# Charlotte Department of Transportation

## Memorandum

**Subject:** Rezoning Petition 08-082: Located on the east side of Matheson Avenue between North Tryon Street and the Southern Railway railroad (*revised*)

MATHESON AVENUE/30th STREET
 CHICK GODLEY RD. AND DRIVEWAY ACCESS PLAN
TECHNICAL DATA SHEET
 PETITION NO. 2008-082

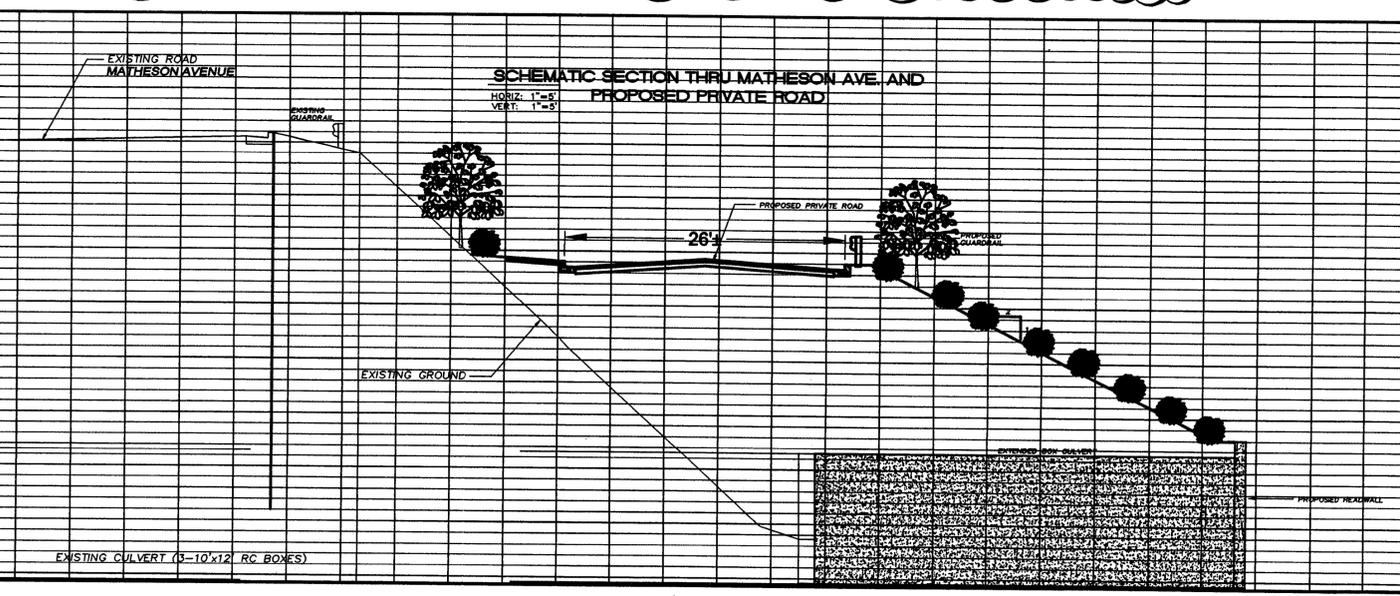
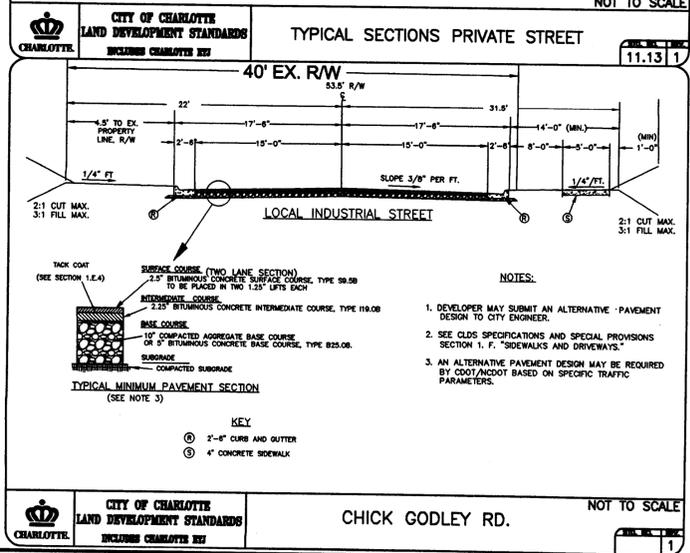
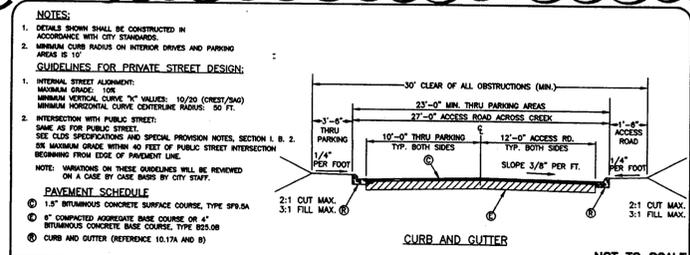
1. A left-turn lane may be required on Matheson Avenue at the public street connection. We will further review the need for the left-turn lane and make a determination following our review of the TIS.

- Meet applicable Charlotte Land Development Standards (latest revision).
- Dimension width of the existing and proposed driveways.
- New/reconstructed driveways must be drop curb ramp Type II-Modified driveways.
- Indicate the locations and widths of all adjacent and opposing driveways.
- Indicate typical parking module dimensions.
- Directional wheelchair ramps (two per corner) should be provided at all intersections of public and private streets.
